**CITY OF PORTLAND**  
**Planning and Urban Development Department**

**MEMORANDUM**

**SUBJECT:** Request for Certificate of Occupancy  
7 Graystone Lane (lot 21)

SINGLE FAMILY PLOT PLAN  
 LOT 21 PHEASANT HILLS SUBDIV.  
 FOR:  
**MR. TED ADAMS**  
 NORMAN BERUBE BUILDERS INC.  
 1040 U.S. ROUTE 1, SACO, ME 04072

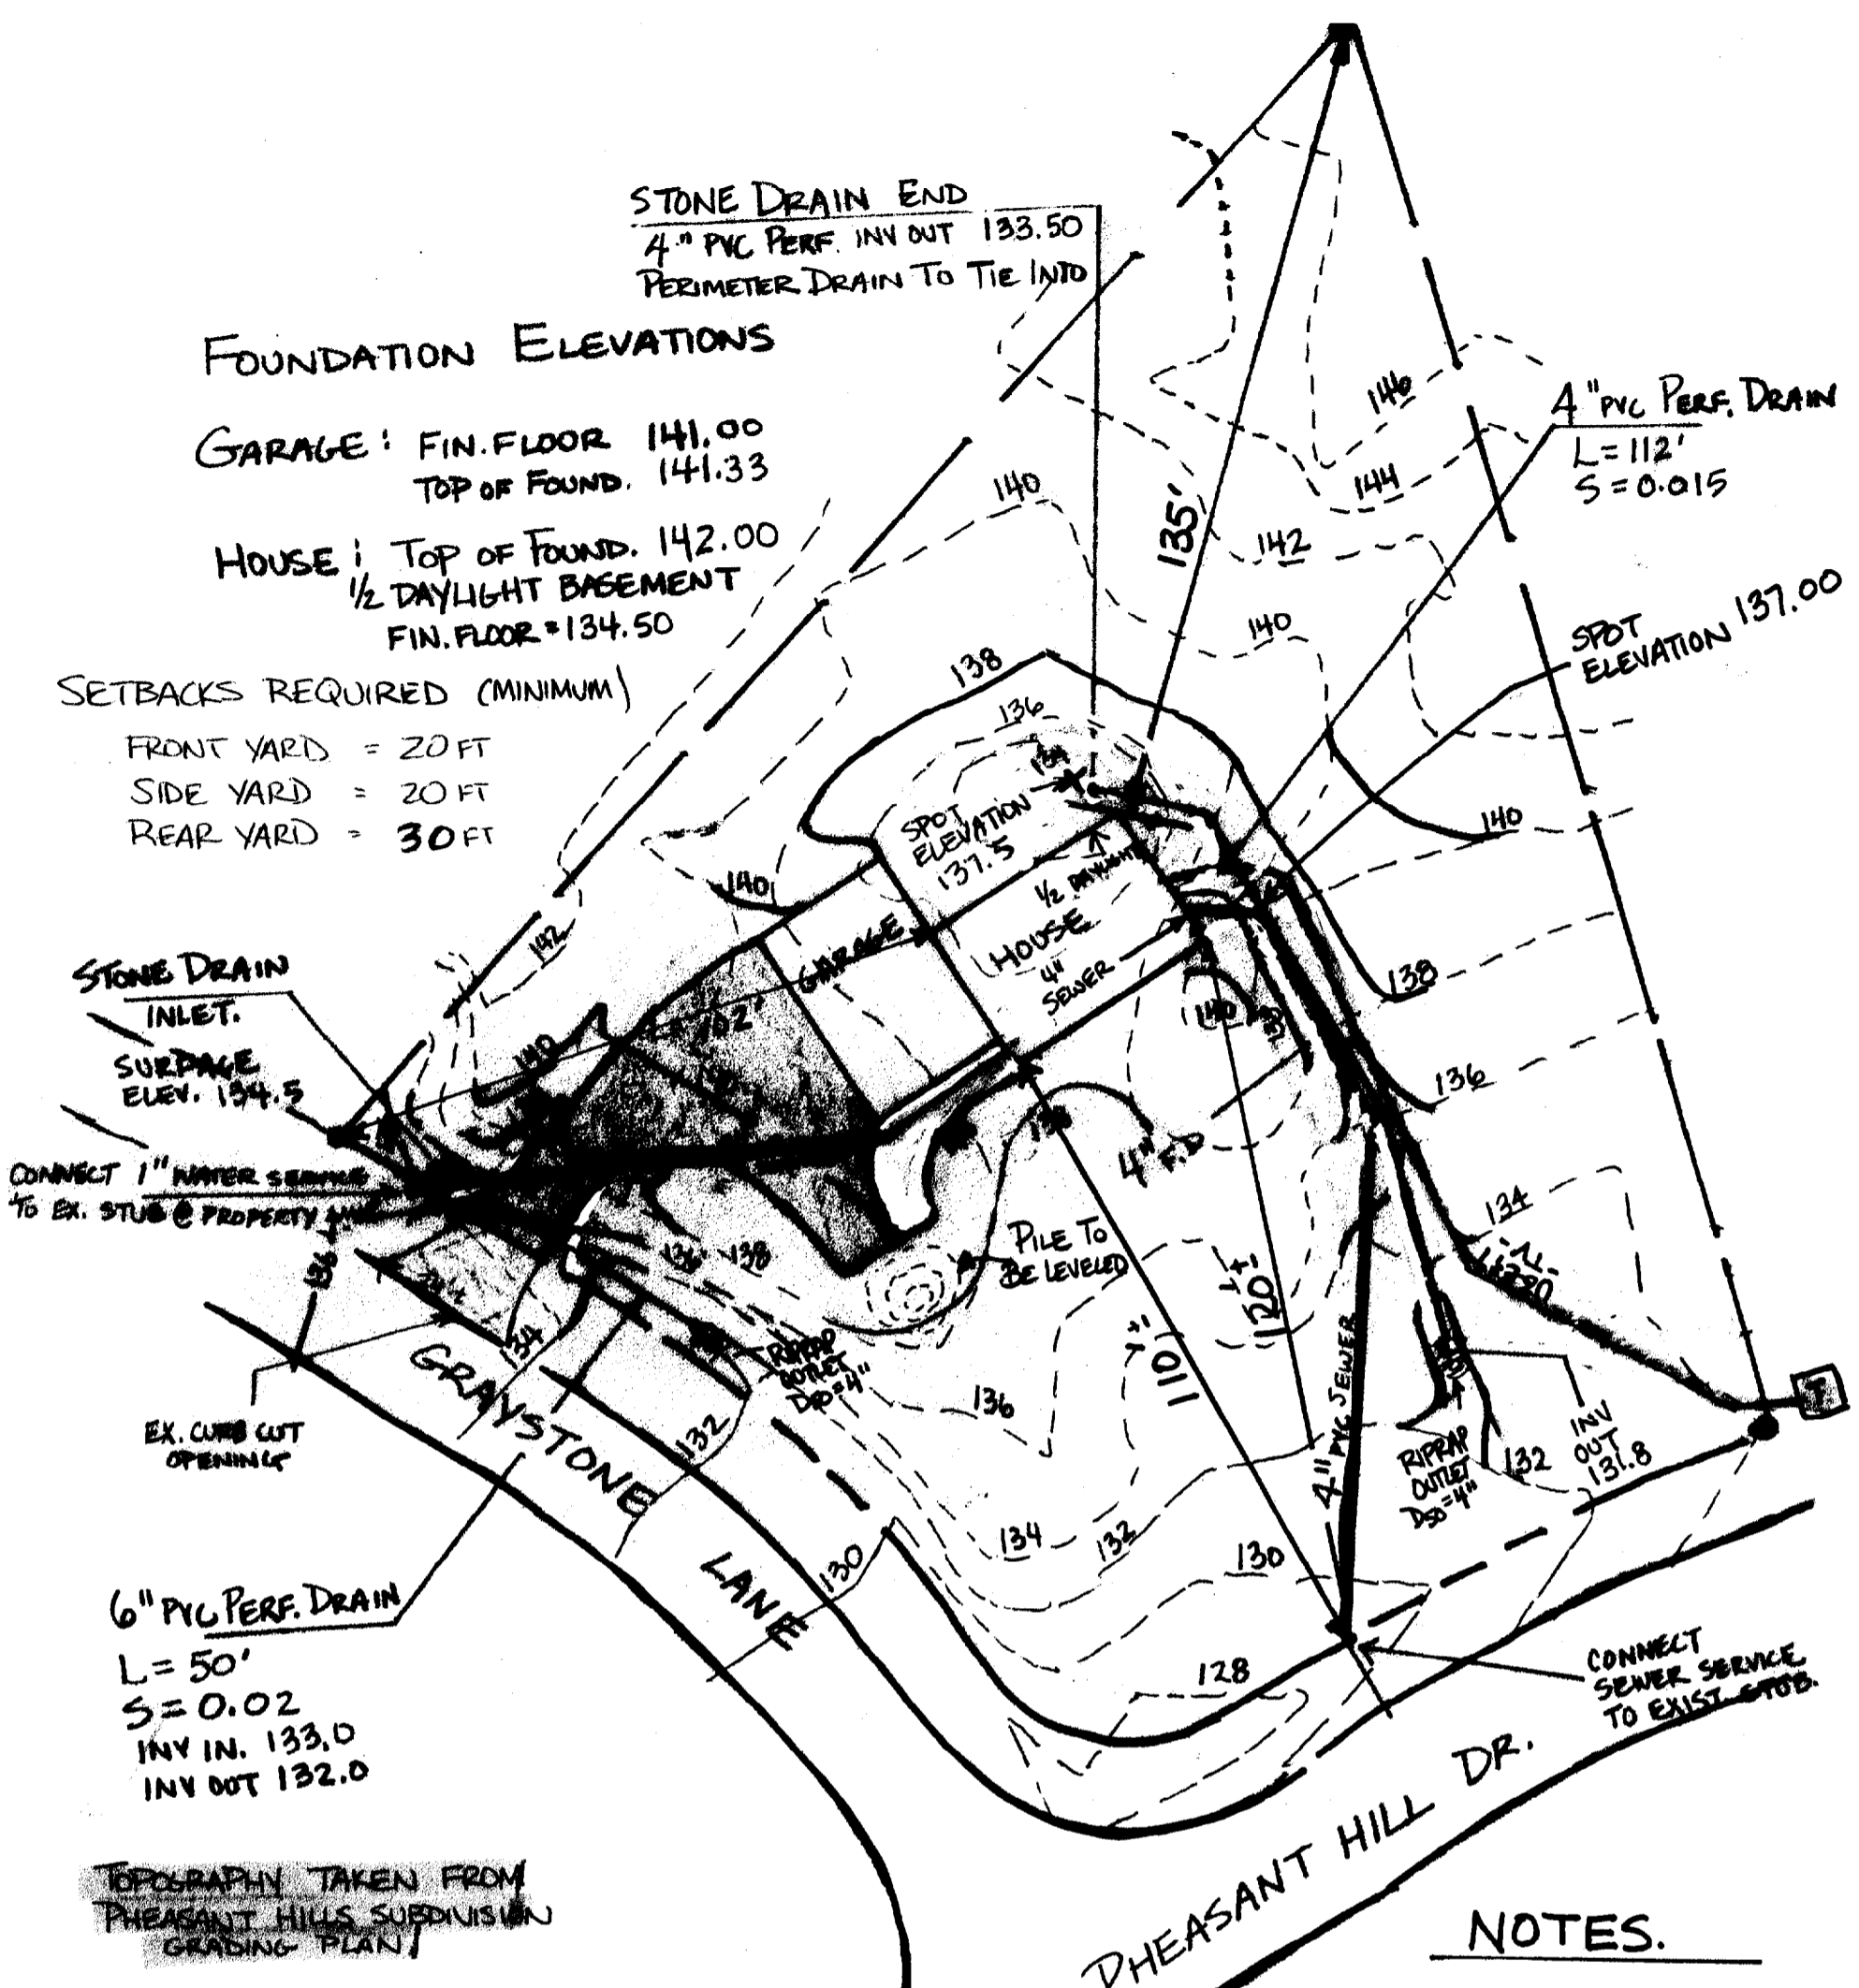
1. Final site grading and landscape work needs to be completed; this work shall be completed by May 31, 1998.
